Formal Objection and Planning Assessment: State Significant Development Application SSD-119133490 (40-56 Ourimbah Road, Mosman)

This submission constitutes an independent, planning and environmental assessment of State Significant Development Application (SSDA) SSD-119133490.¹ The application proposes the demolition of existing structures across a consolidated site and the construction of an eight-to-nine-storey residential flat building comprising 63 apartments, inclusive of an in-fill affordable housing component, over a two-level subterranean basement at 40-56 Ourimbah Road, Mosman.² This submission articulates the severe, unmitigated impacts the development will impose upon the immediately adjacent heritage-listed property at 33 Bond Street, Mosman (Item 131), alongside broader ramifications for the surrounding local character and municipal infrastructure.³

Figure 1 Wall height exceedance – Long section facing north (Source: Doroch Architects and Gyde Consulting Markups)

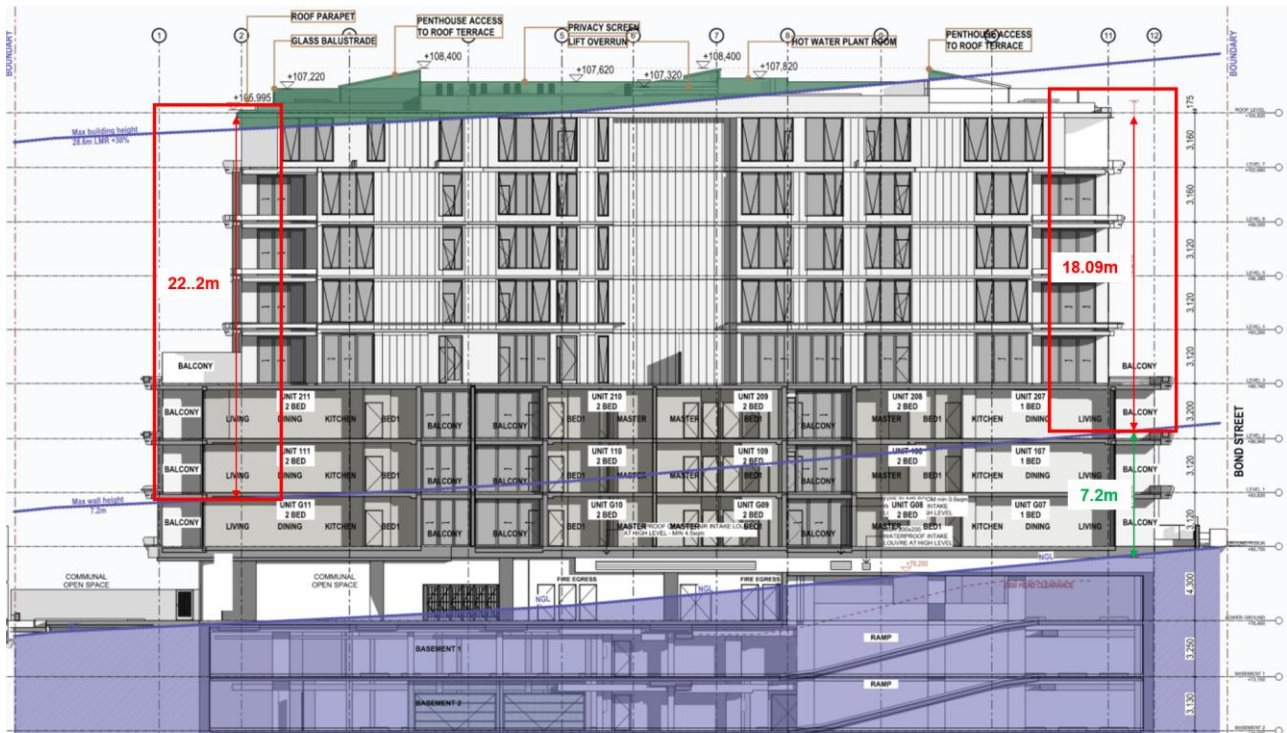
Beyond the breach of the overall building height, the proposal exhibits an even more alarming disregard for the streetscape interface. The Mosman LEP 2012 establishes a maximum wall height standard of 7.2 metres for the R3 zone to ensure that new developments present a modulated, human-scale interface to the public domain and adjoining low-scale properties. The proposed development abandons this modulation entirely, introducing a sheer, unbroken wall height of 29.42 metres.

This constitutes a staggering variation of over 300% from the local standard. The applicant's scoping report signals an intention to submit a Clause 4.6 variation request to bypass this standard, arguing an inconsistency between local controls and the new Housing SEPP.¹

However, established jurisprudence dictates that Clause 4.6 of the Standard Instrument LEP is designed to allow flexibility for minor, justifiable variations that result in a better planning outcome. It cannot be utilized as a legislative bulldozer to facilitate a 300% exceedance that effectively abandons the control altogether. Approving a sheer 29.42-metre wall directly adjacent to the 1896 heritage dwellings on Bond Street ensures maximum visual dominance, overshadowing, and the total destruction of the fine-grain character that the wall height control was explicitly drafted to protect.

Figure 2 Extent of the height variation from highest point of the building (Source: Doroch Architects and Gyde Consulting Markups)

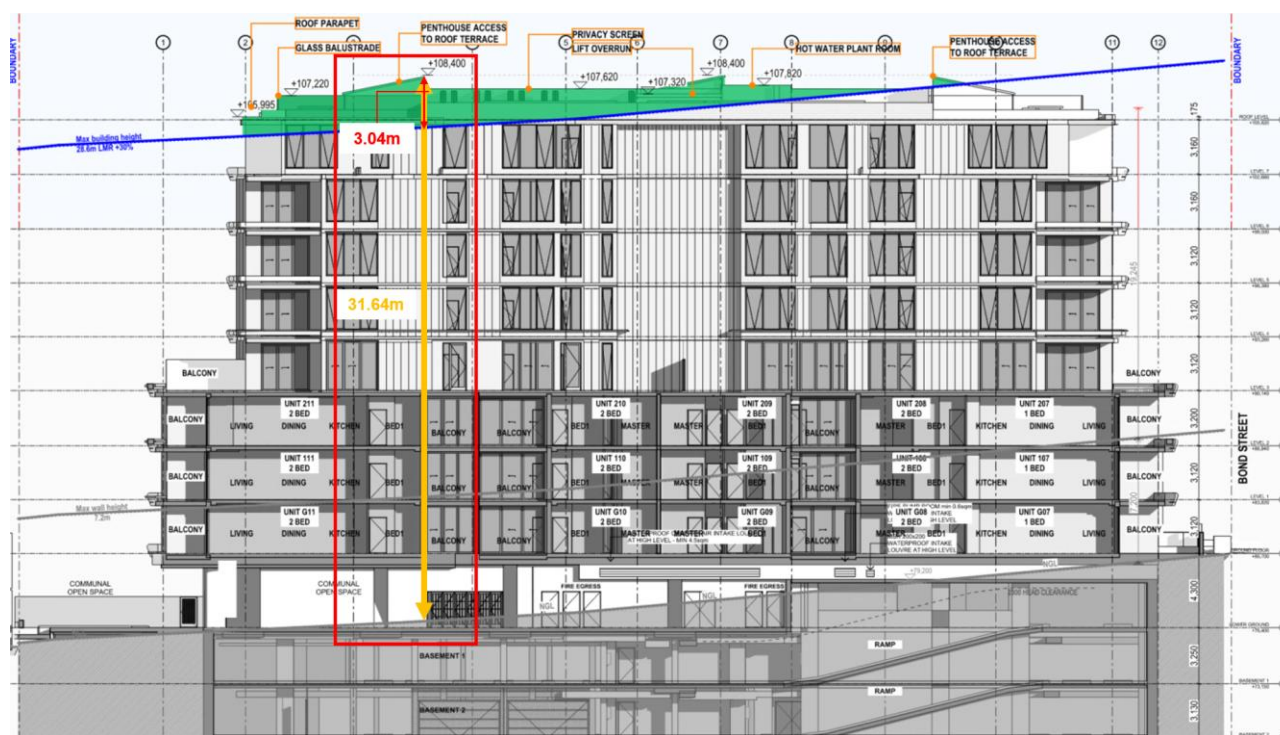
Firstly, the development introduces a staggering building height of 31.64 metres, accommodating eight-to-nine storeys.² This blatantly breaches the statutory base limit of 22 metres (six storeys) for the applicable zone, as well as the absolute maximum 28.6-metre cap allowed even when the maximum 30% affordable housing bonus is applied.⁶ Additionally, the sheer wall height of 29.42 metres violates the Mosman Local Environmental Plan (LEP) R3 standard of 7.2 metres by an unprecedented margin of over 300%.

The submitted architectural documentation and project details reveal that the proposed development flagrantly ignores these absolute ceilings. The proposed overall building height reaches 31.64 metres, comprising an excessive 8-to-9 storeys.¹ This represents an architectural massing that is approximately 44% above the original base 22-metre limit, and fully 3.04 metres above the maximum possible 28.6-metre cap permitted under the 30% affordable housing

The proposed 31.6m height represents a significant 44% increase over the SEPP base limit and blatantly breaches the absolute maximum 28.6m cap permitted by the 30% affordable housing bonus.

Table 4 Extracts of the shadow diagrams within existing context (Source: Doroch Architects)

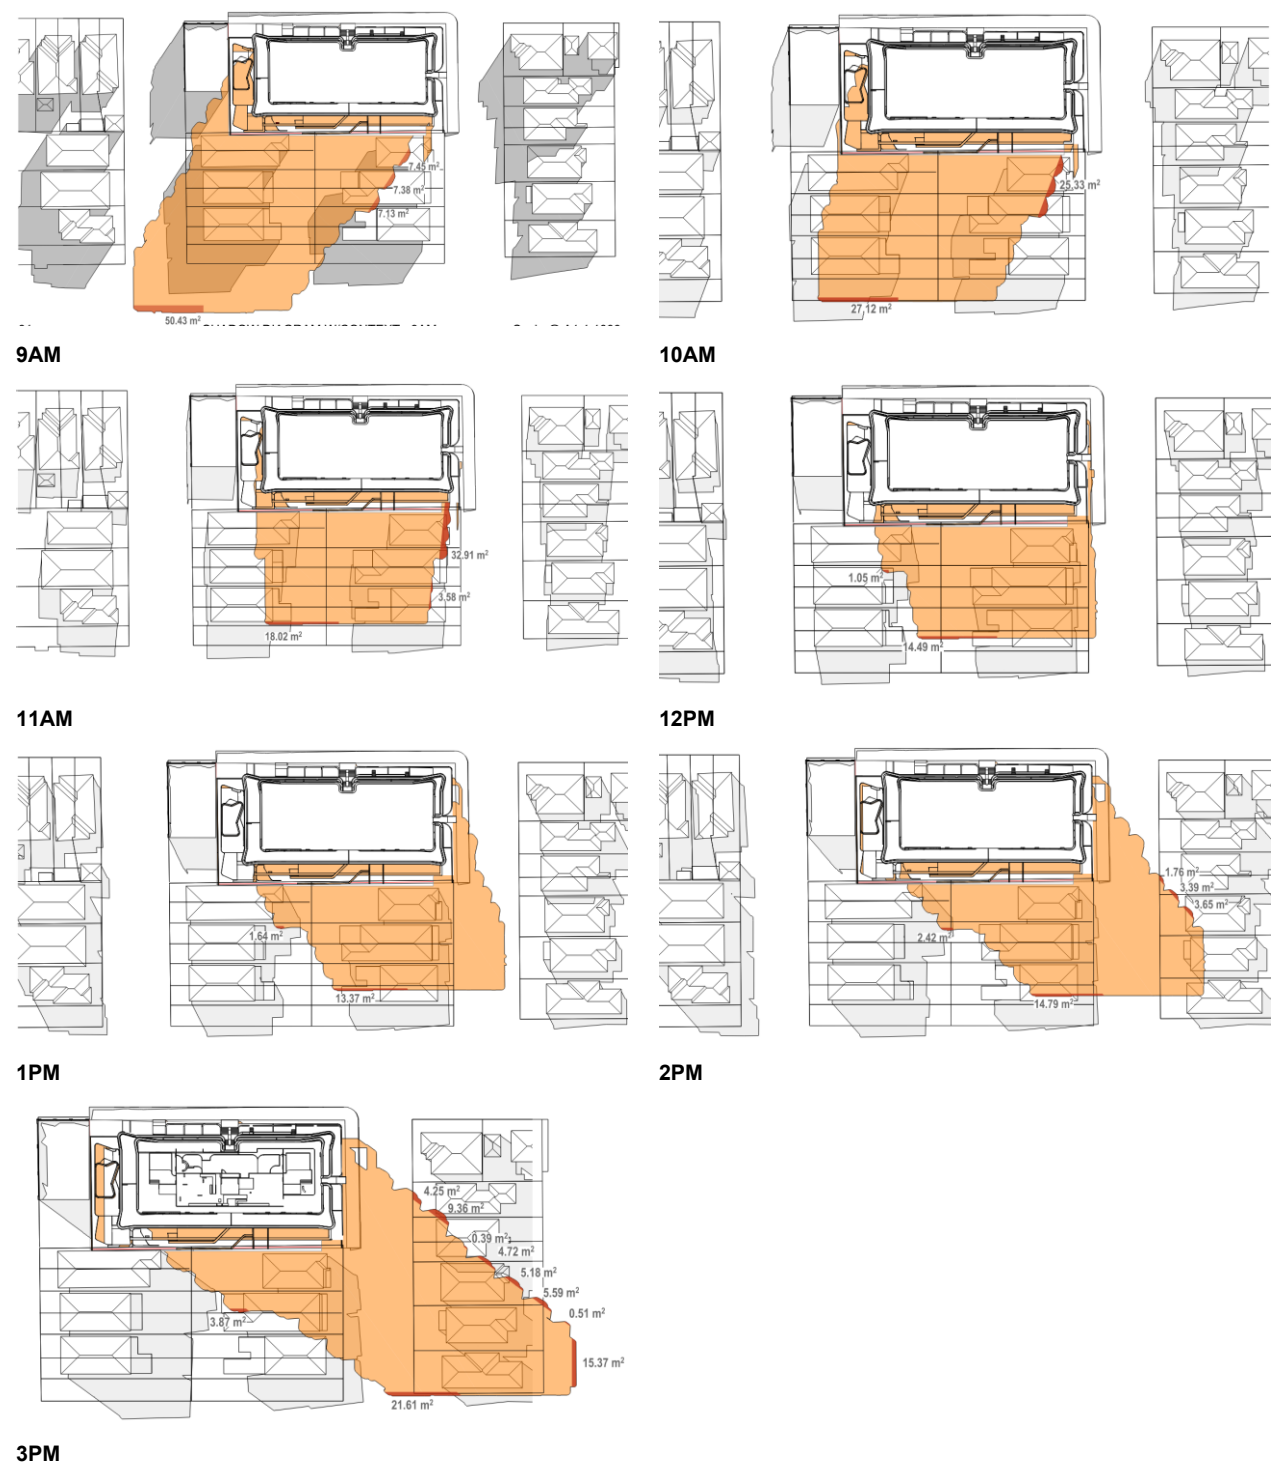
In Appendix 08 (Architectural Plans), the applicant provides a series of shadow diagrams to evaluate the solar access impacts of the 8-to-9-storey tower on surrounding properties.¹ Crucially, drawings A239 through A244 are labeled "SHADOW DIAGRAMS - FUTURE CONTEXT".¹ A review of the statement of compliance within these plans confirms that the applicant has modeled the solar access impacts against a speculative, unrealized amalgamation pattern. The modeling assumes that neighboring lots—including the heritage items on Bond Street and Rosebery Street—have already been demolished and replaced with hypothetical 6-to-8-storey buildings built to the absolute limits of the SEPP boundaries.¹ This methodology is fundamentally flawed and represents a distortion of environmental planning assessment practices. Planning law requires a development's impacts to be assessed against the *existing* built environment, not a hypothetical future where the neighbourhood has already been razed and maximized. By simulating a baseline where towering structures already flank the site, the applicant artificially shrinks the perceived shadow cast by their own 31.64-metre building, arguing that the shadow falls onto the roofs of these imaginary future towers rather than into the private open spaces of existing homes.

The existing reality is that the site is bounded by low-scale 1-to-2-storey residential dwellings, including 33 Bond Street.¹ The true shadow cast by a 9-storey, 31.64-metre building onto these low-lying nineteenth and early twentieth-century homes during the winter solstice will be devastating. The development will deprive adjacent primary living areas and private open spaces of critical solar access, directly contravening the amenity objectives of the Apartment Design Guide (ADG) and local controls.

The application's reliance on "Future Context" sun-eye diagrams and shadow modeling indicates an implicit admission that the proposed massing cannot satisfy solar access compliance without relying on speculative fiction. Evaluating a major development based on the assumption that surrounding heritage items and single-family homes will eventually be destroyed to match its scale sets a dangerous precedent and masks the immediate loss of amenity for current residents.
